Your Ref :
Our Ref : BR/133/14/NMA

Application for non-material amendment following a grant of planning permission BR/256/10 - relating to render to ground floor
Melrose, 7A Nelson Road, Aldwick,

4 North
1 : 100

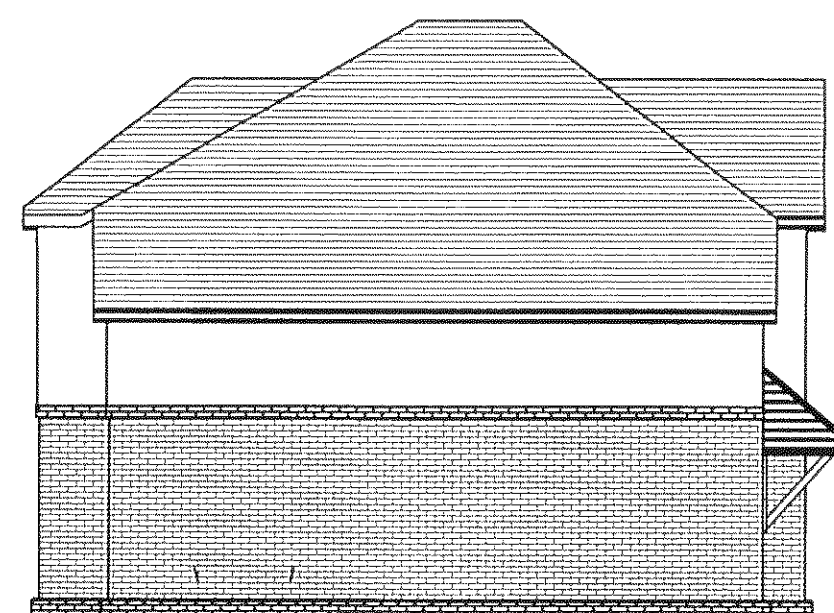
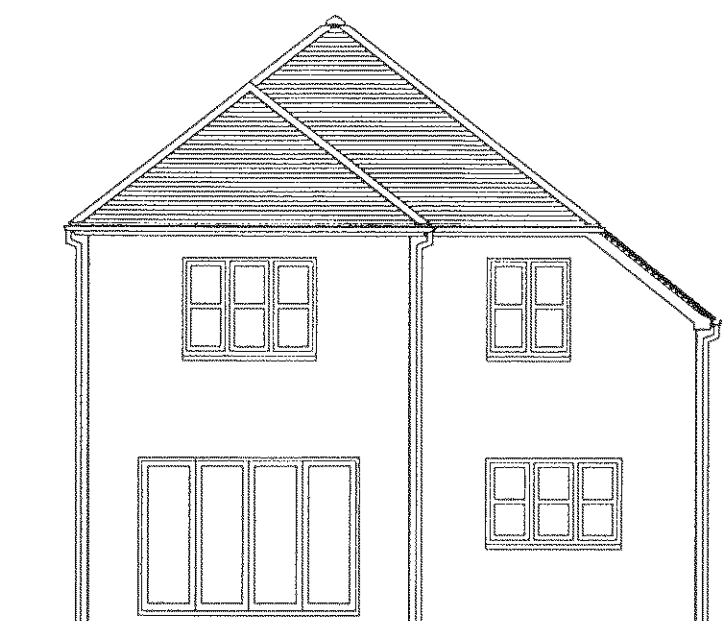
I refer to your recent application for a non-material minor amendment received on 03 June 2014 and relating to planning permission Ref BR/256/10. The application states that the reason for the amendment is the use of render at ground floor rather than brick. However, I also note that there are alterations to the proposed fenestration in the north and south elevations. This comprises a reduction in the number of windows in the northern elevation and a slight increase in the amount of glazing to the southern facing lounge window.

Notwithstanding, I do not find any of the changes to be harmful to the amenity of neighbours or to the character & appearance of the streetscene. I therefore consider that the changes are not sufficiently significant so as to warrant a fresh application and that the amendment is capable of being a minor amendment to application ref BR/256/10.
